BIG O TIRES

6985 N. MERIDIAN ROAD, PEYTON, CO 80831

GRADING AND EROSION CONTROL PLANS El Paso County, Colorado

PCD PROJECT NO. SF-18-003

SHEET: **C1.1**

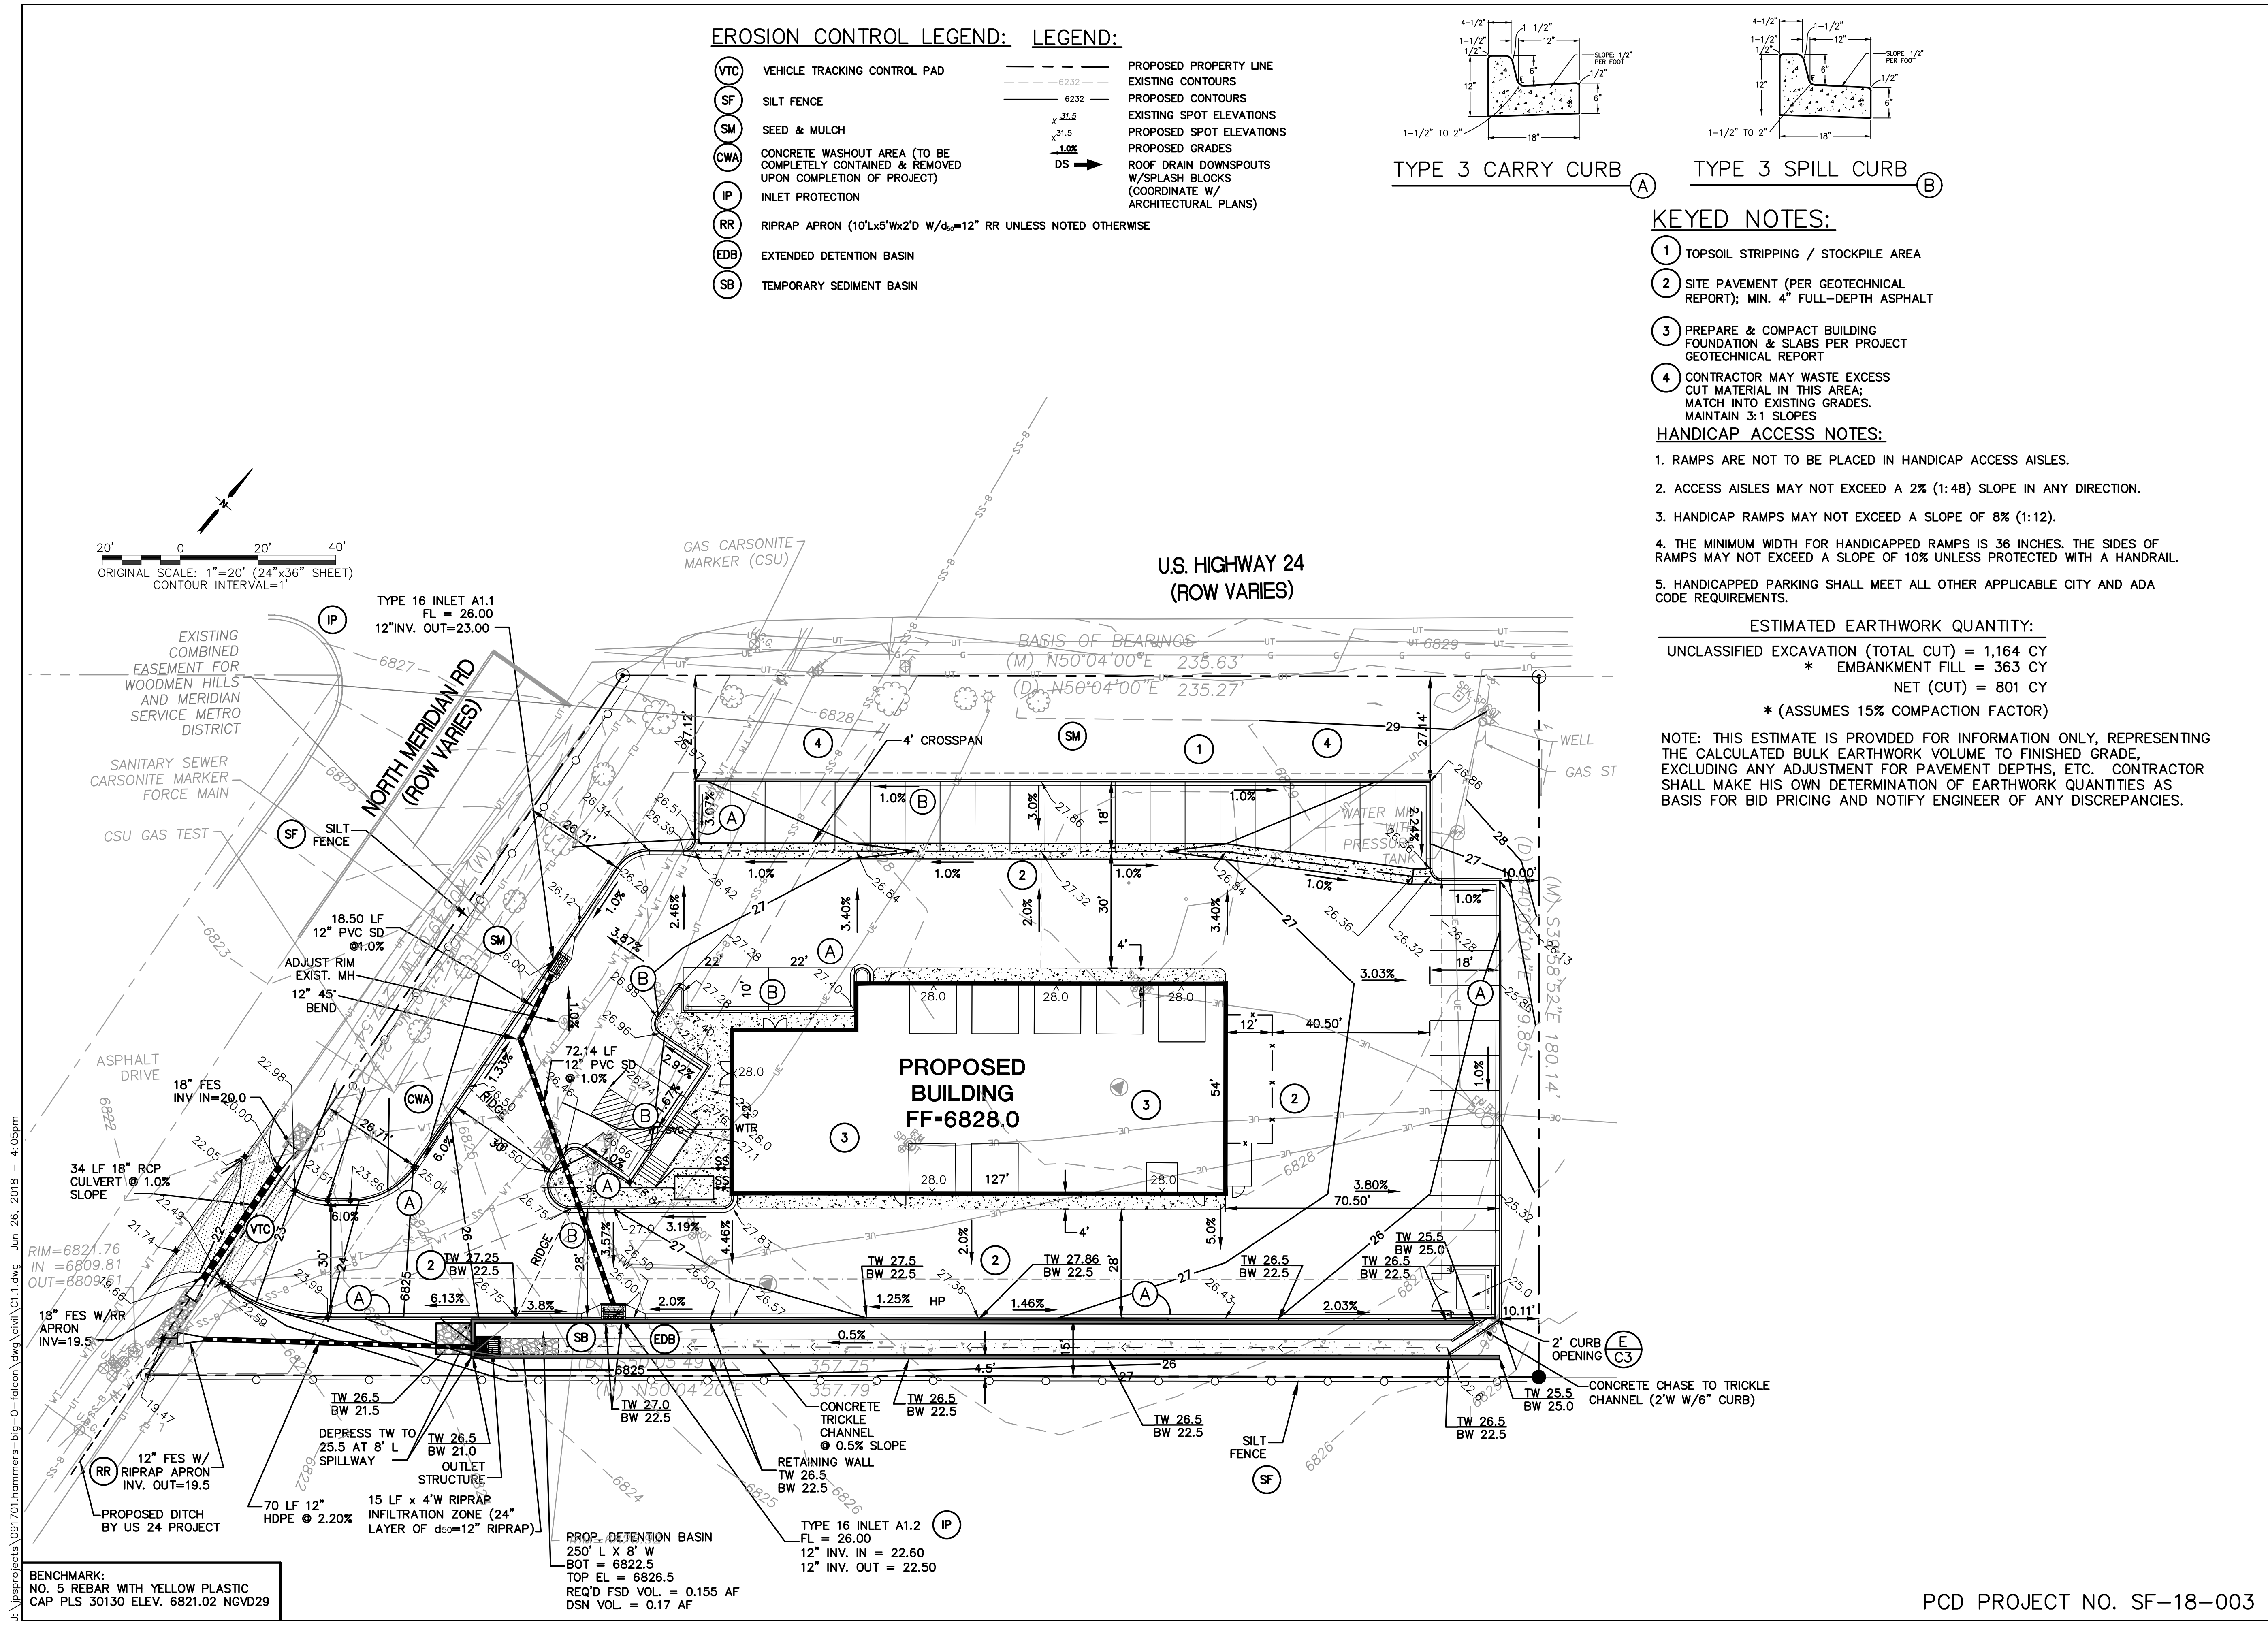
See the drainage report for detention pond comments. Pond design may need to be revised.

ORIFICE PLATE AND TRASH RACK DETAILS AND NOTES
NTS

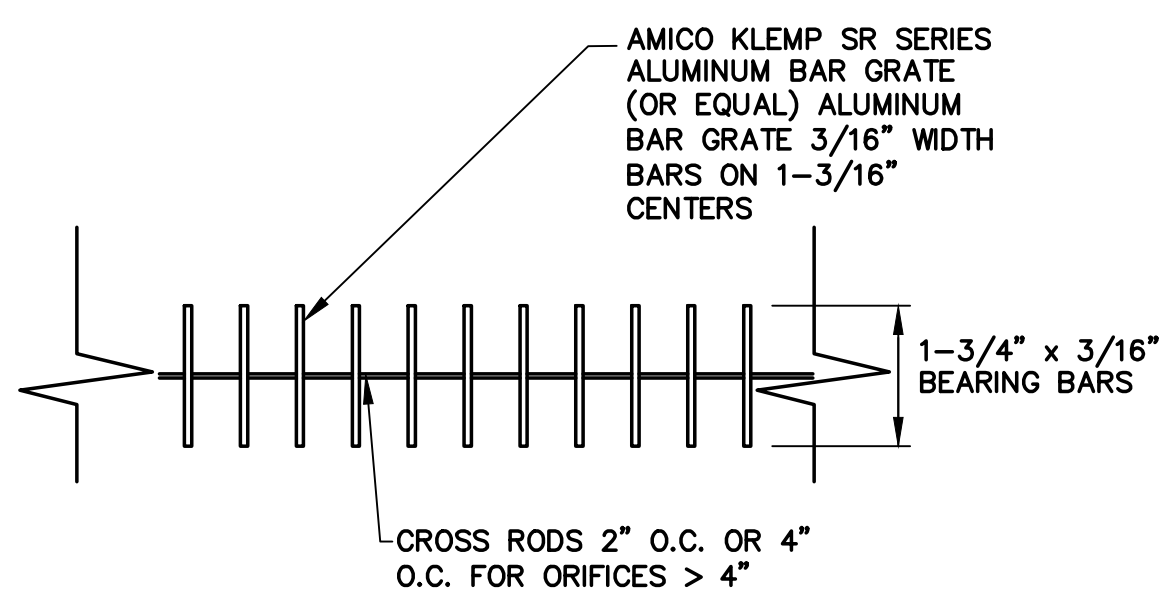
Revise to 1-3/4" x 3/16"
(FYI: dimension obtained from UDFCD DCM Volume 3 Figure OS-6)

For clarification on how the bar grate is configured, include the cross section detail C for UDFCD DCM Volume 3 Figure OS-6.
